Comments for planning application **2021/62/93013**. Erection of two storey side, single storey rear, and rear dormer extensions, and demolition of the existing garage at 74 Cleveland Road, Marsh HD1 4PW.

Client	Usman	Issued From	
Project	1968 : 74 Cleveland Road : Domestic Extension	Date	February 20
Title	Proposed Ground and First Floor Plans	Scale	1:100 @ A1
Drawn	BH	Auth	BH
Drawing Number	1968 - D - 20 - 004	Revision	C

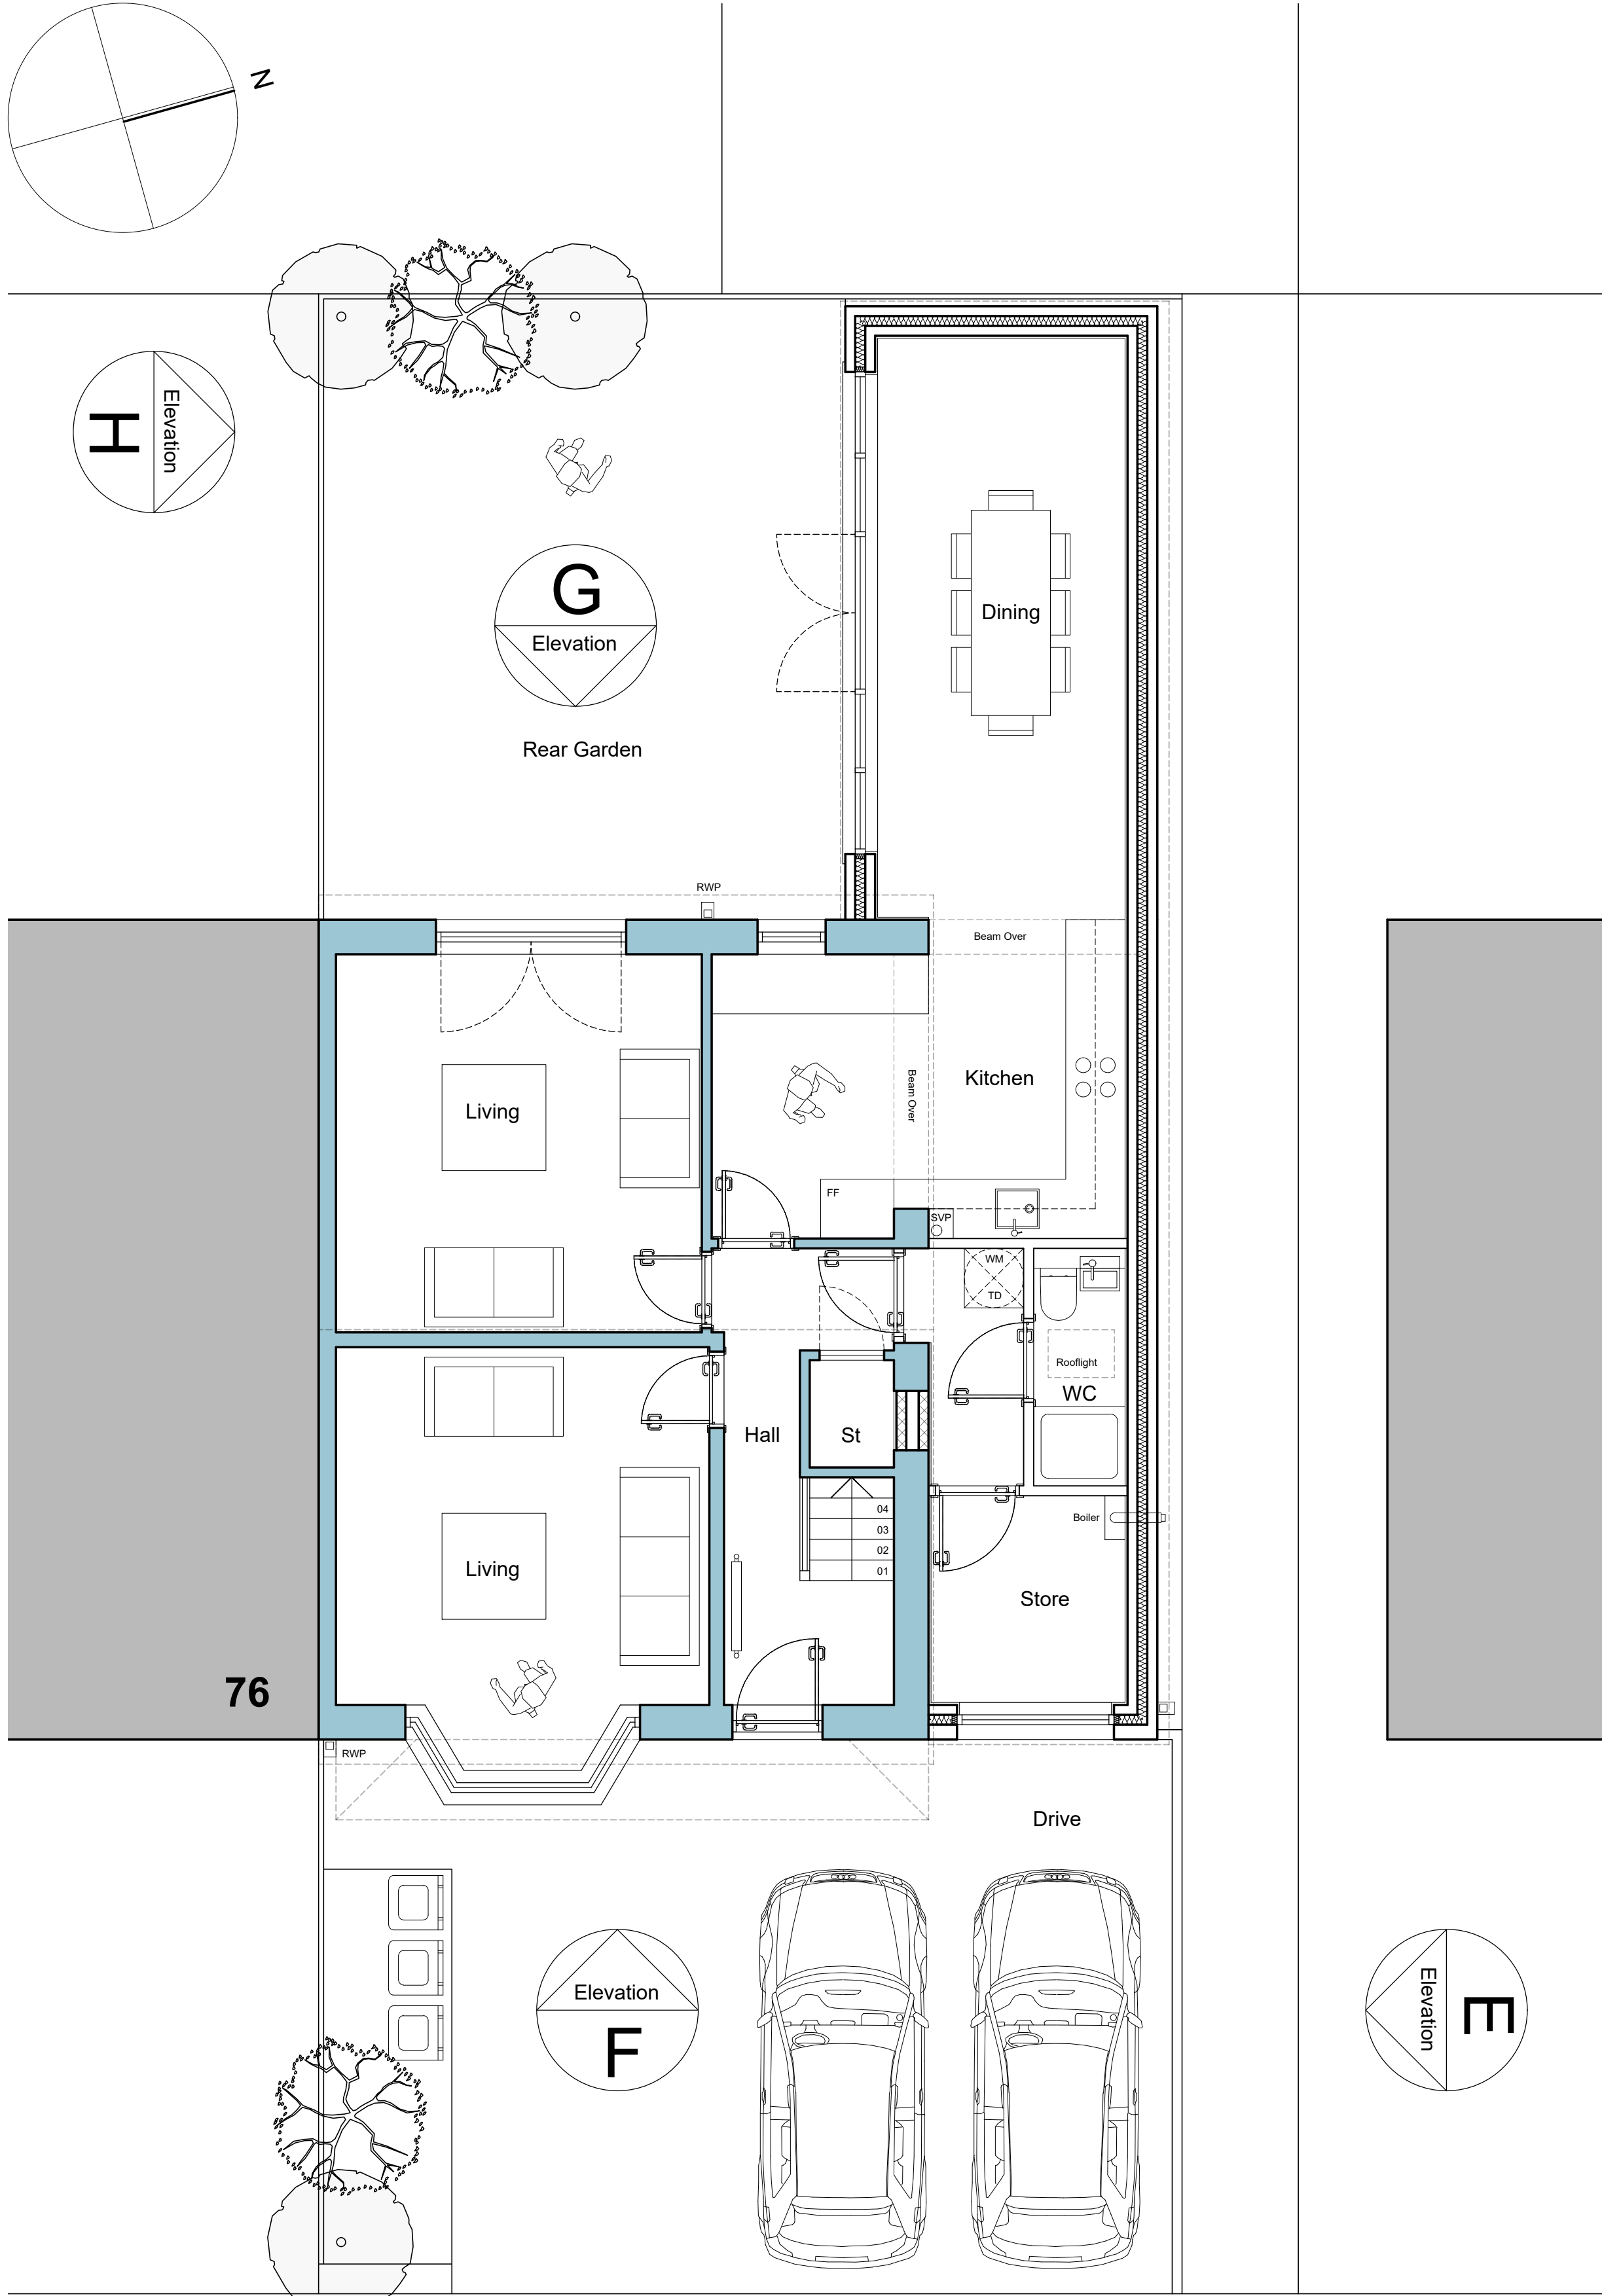
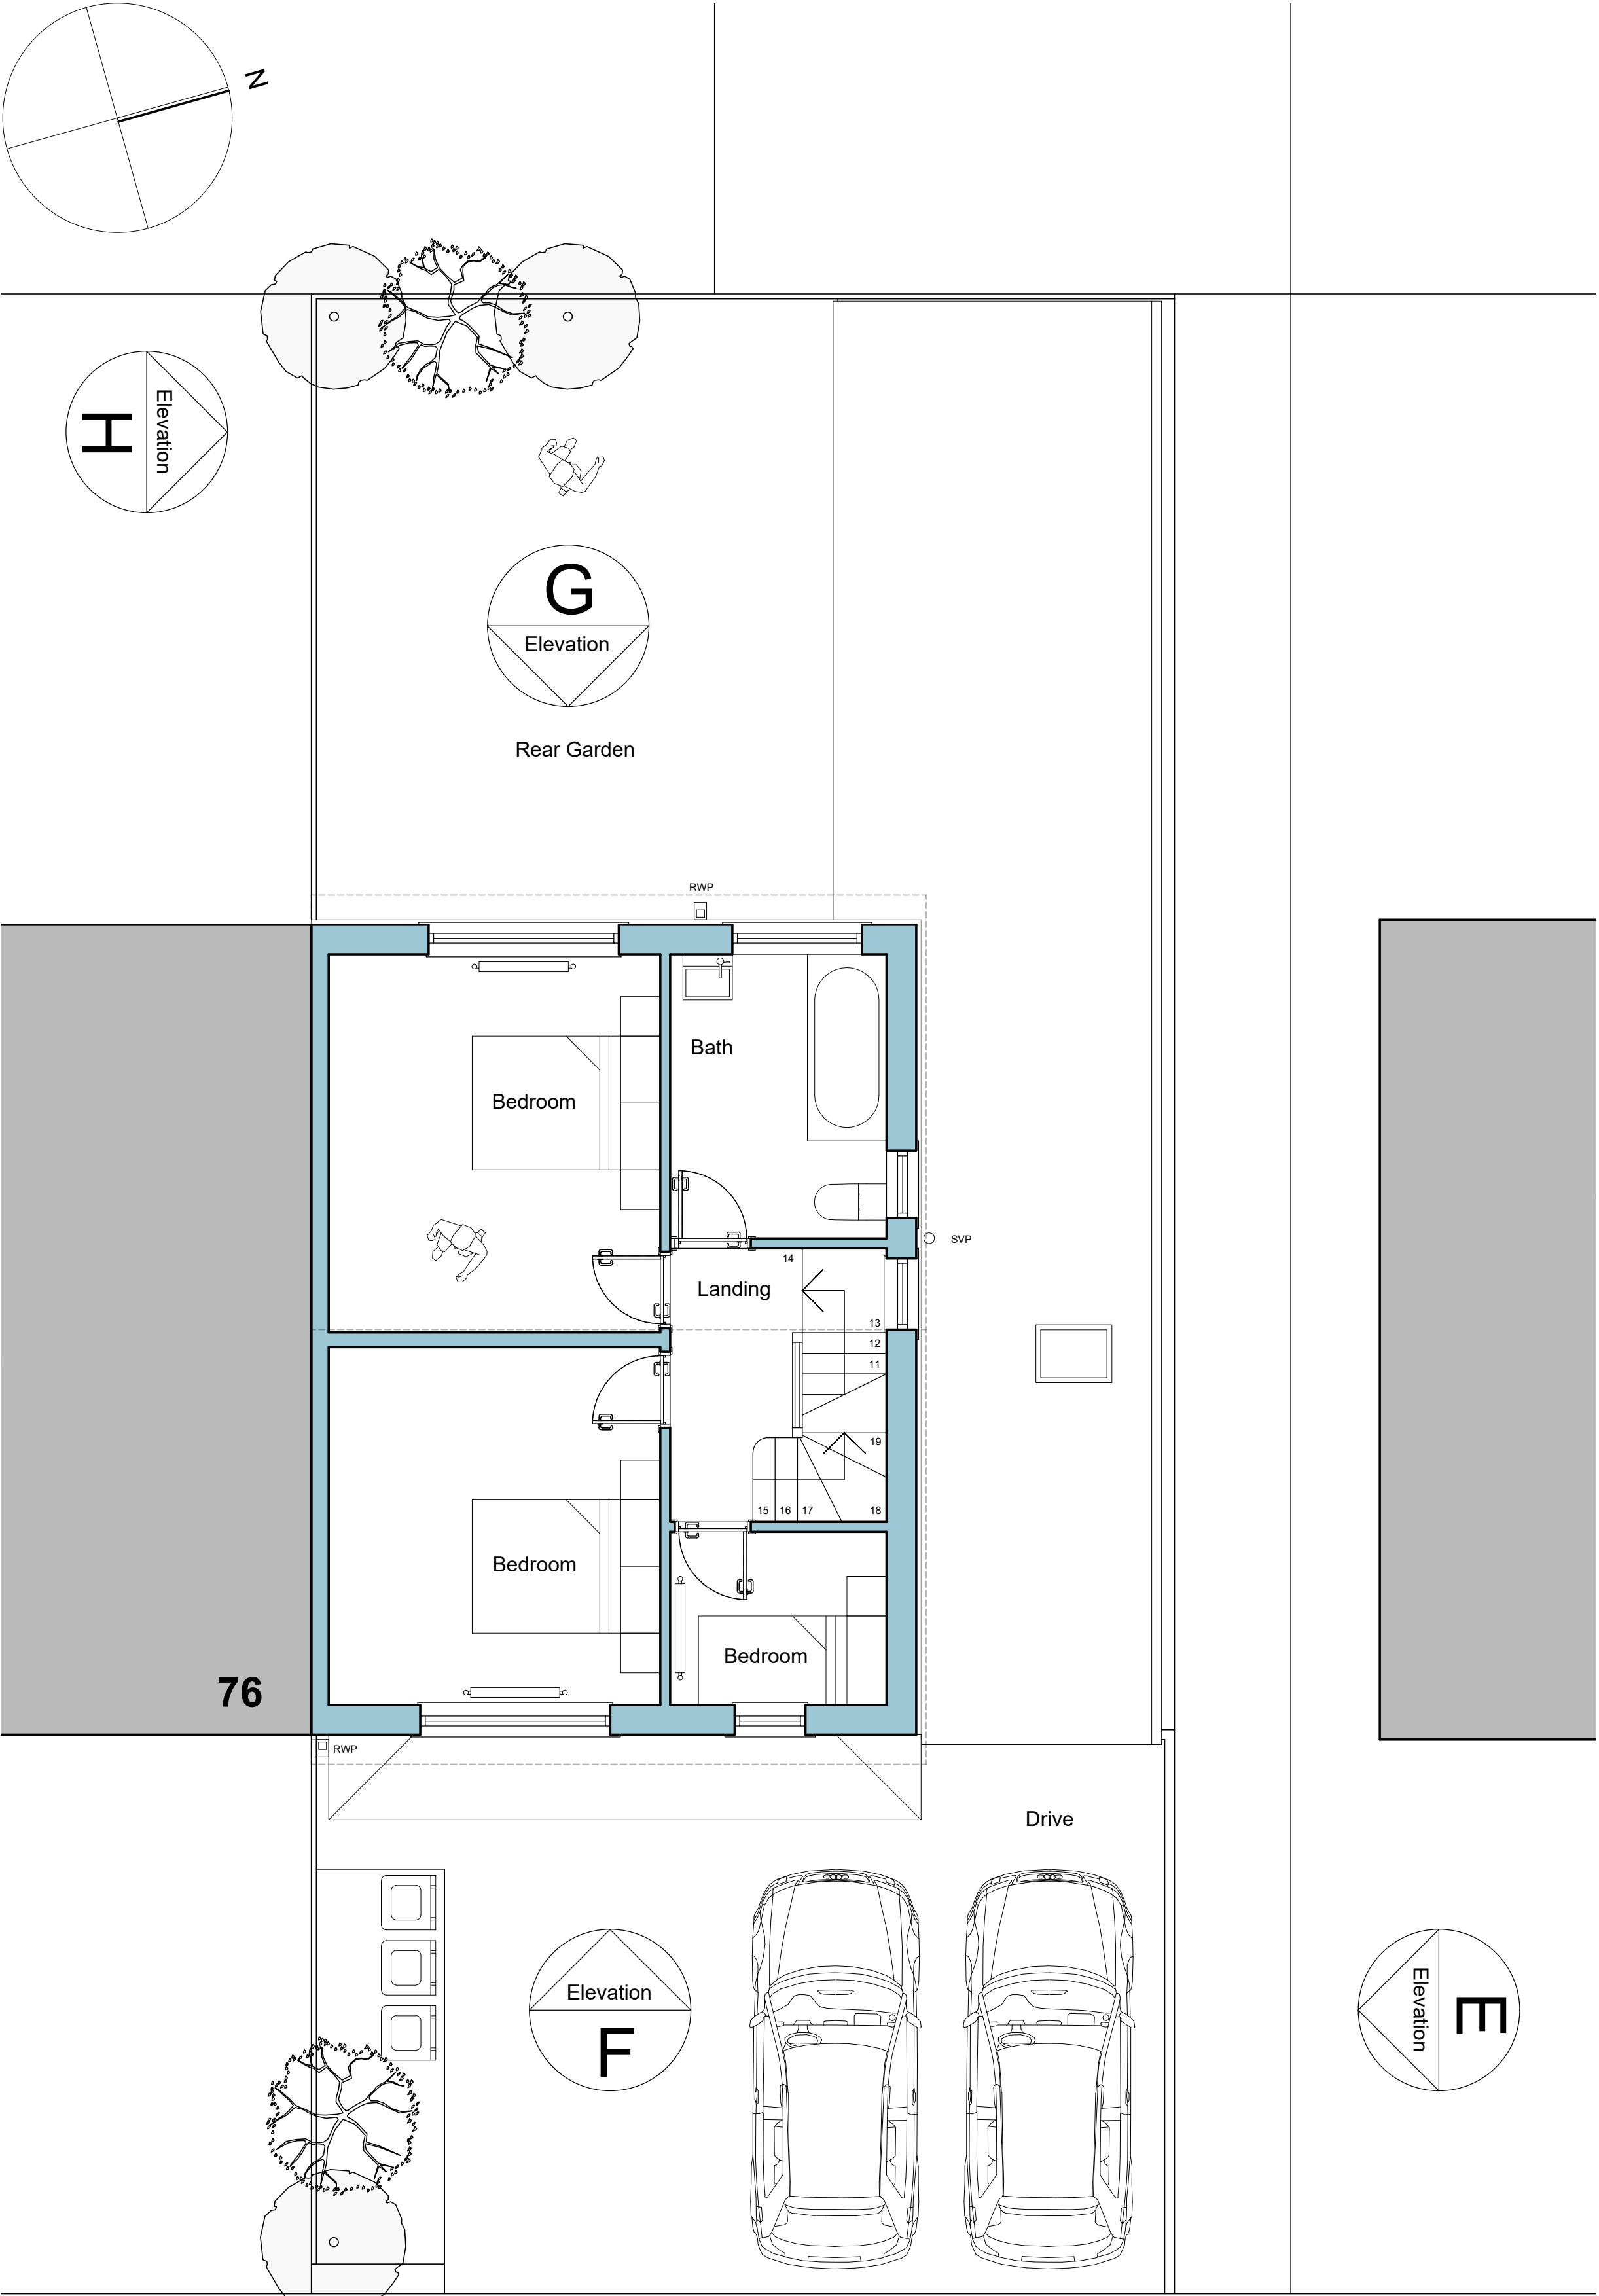
I appreciate that this may be separate to the planning application process, but I feel it also important to raise the issue of an access door shown on the submitted plans, which leads from the proposed single storey extension out onto land within my ownership/control where I have an access from my rear garden to Cleveland Road. There is no right of access by the owner/occupier of 74 Cleveland Road onto this land nor have there been any discussions to suggest otherwise. As it stands, this is not currently an available access point to or from the property at 74 Cleveland Road.
